PLANNING WORKSHEET 11 – DELEGATED / PCG REPORT - HOUSEHOLDER

Application Ref.	22/00954/HSE	
Site Address	Lorelei Lodge South Street Bole Retford Nottinghamshire	
Proposal	Porch to Front Elevation	
Case Officer	Ellie Grant	
Decision Level	Delegated	
Reason(s) for PCG referral		
PCG Sign off and date		
	Signature	Date
Case Officer	Ellie Grant	08/09/2022
Principal Planner		
Authorised signing Manager		8 th September 2022

The Proposal	The application proposes to erect a porch extension to the front of the dwelling. It will measure approximately 5.6 metres wide, 3.3 metres deep and be 3 metres tall with a gently sloping roof. It is larger than what is allowed via permitted development and proposed in different materials so planning permission is required.
Assessment of Proposal	<p><u>Principle of Development</u></p> <p>Planning permission is sought to carry out works within the curtilage of an existing residential property. Paragraph 12 of the NPPF makes it clear that the development plan is the starting point for decision-making.</p> <p>The NPPF adds that in the absence of an up-to-date local plan or relevant development plan policies, permission should be granted unless it is clear

front (west) elevation

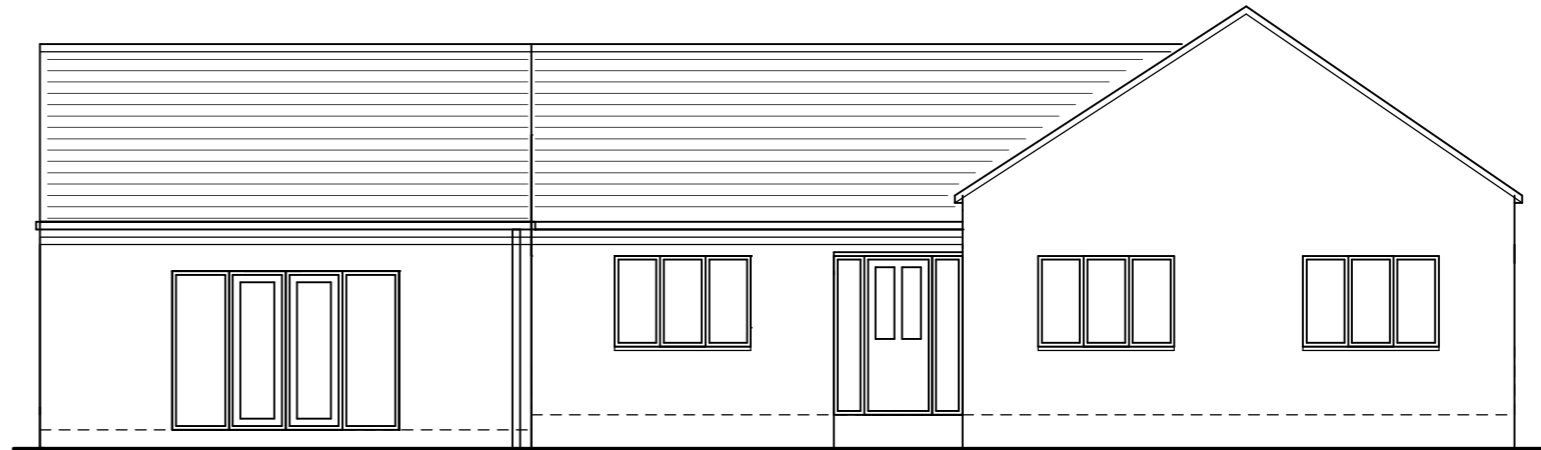
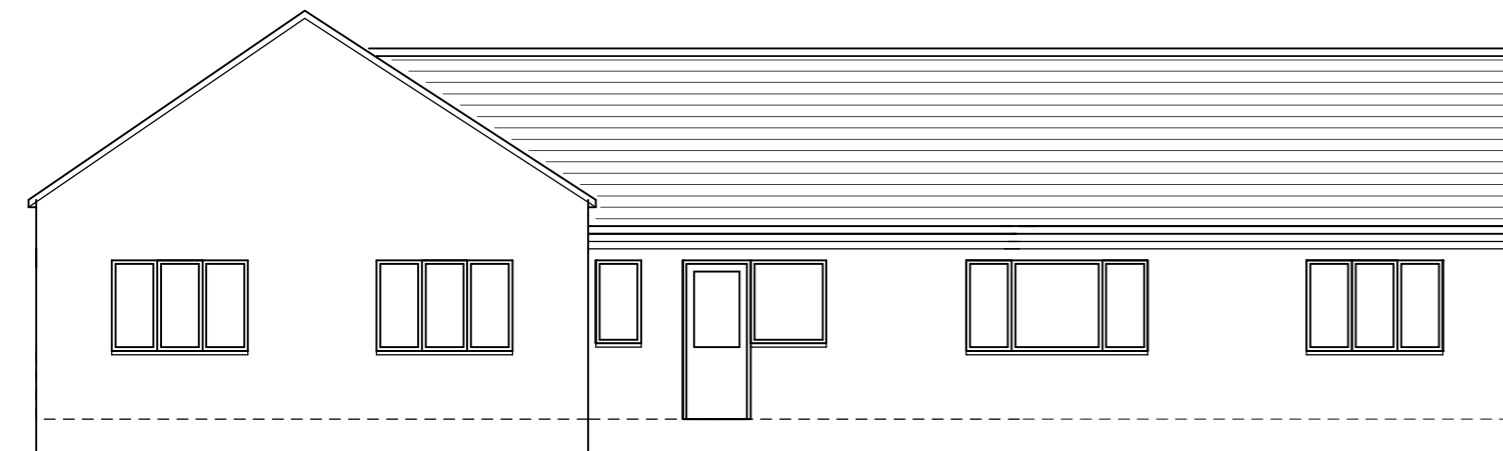
The porch extension will be constructed of uPVC with oak effect panelling and frames, with a polycarbonate roof. There will be a set of French doors placed centrally to the front. This will become the front entrance to the property and the original front door will not be visible.

The design of the porch extension is of concern. Whilst the windows of the existing dwelling are UPVC, the structure proposed does not match the materials used in the construction of the dwelling, which is brick and tile. The structure will be placed on the front of the dwelling and so will be a prominent addition and would appear a somewhat incongruous addition to the front of the property. As such, it is felt to weaken the appearance and character of the property.

An alternative design of brick and tile roof construction would be encouraged so as to be more sympathetic to the appearance of the dwelling and to be of a greater longevity than a uPVC structure.

GROUND FLOOR LAYOUT

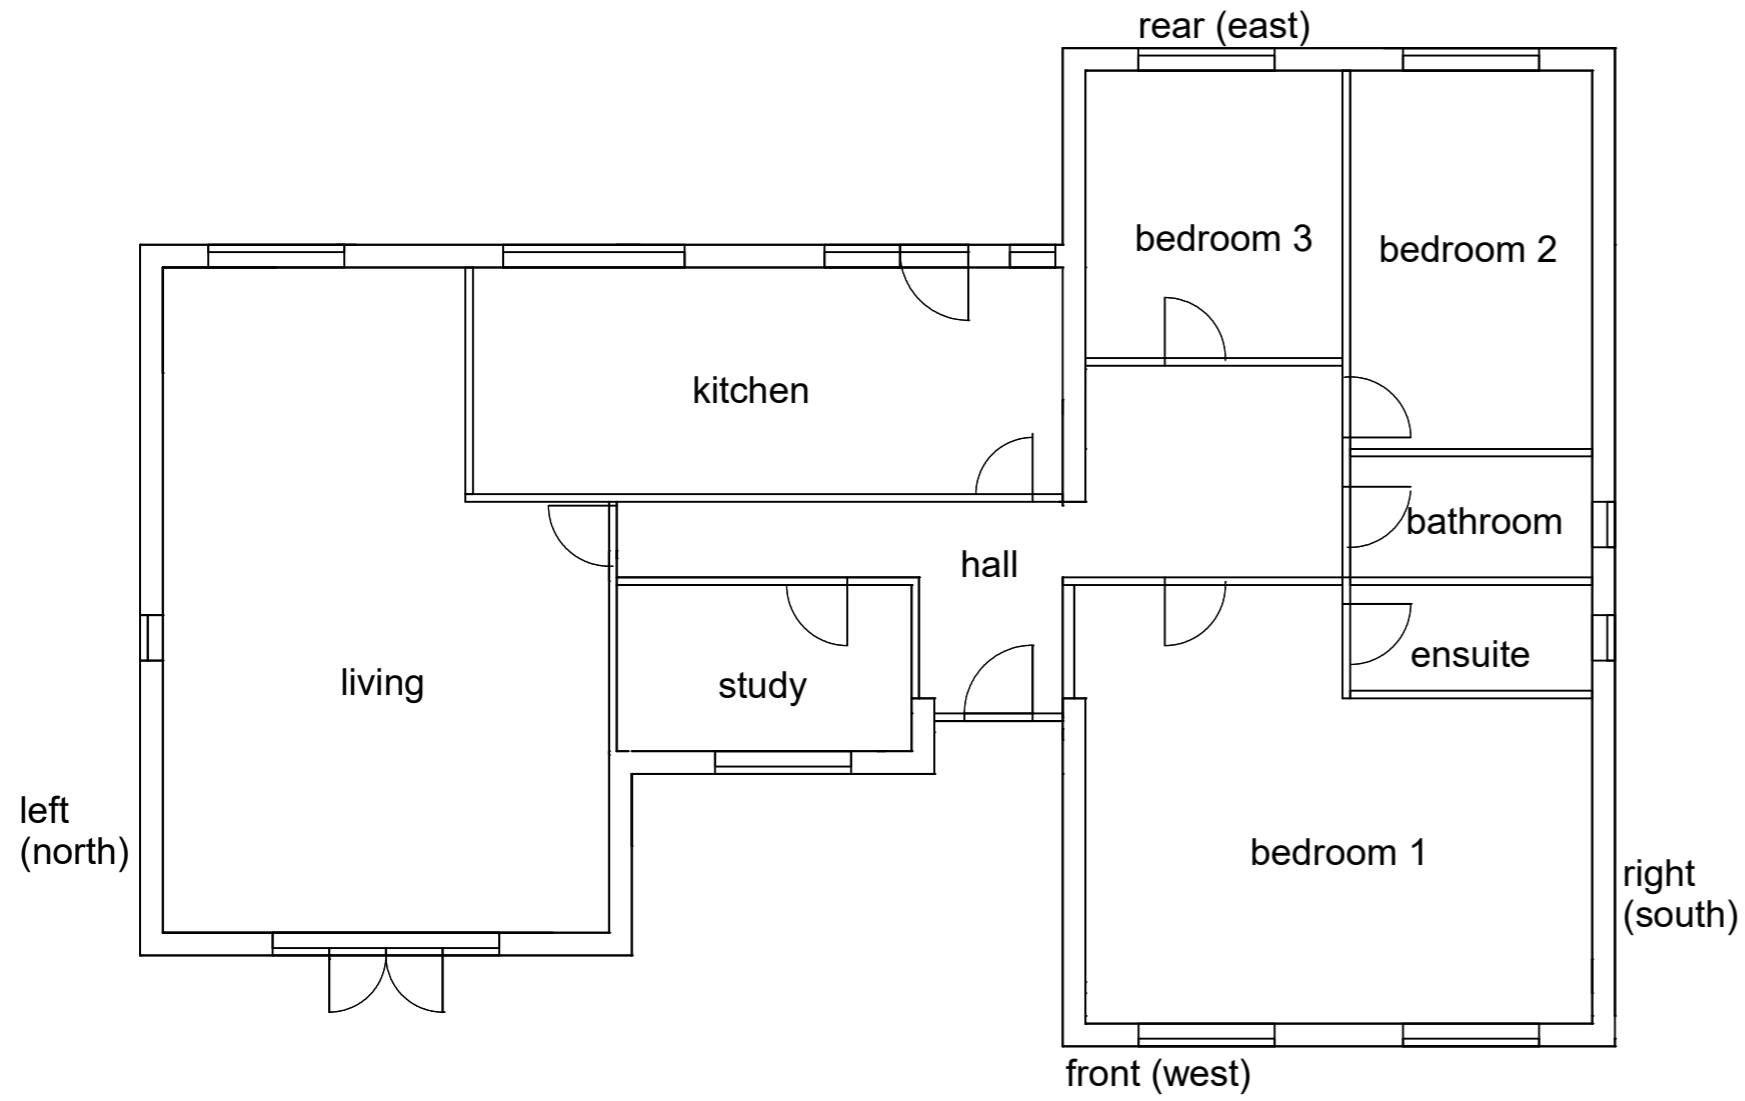
The porch is proposed to infill a section between the projecting gable and the catslide roof which both extend to the front of the dwelling.
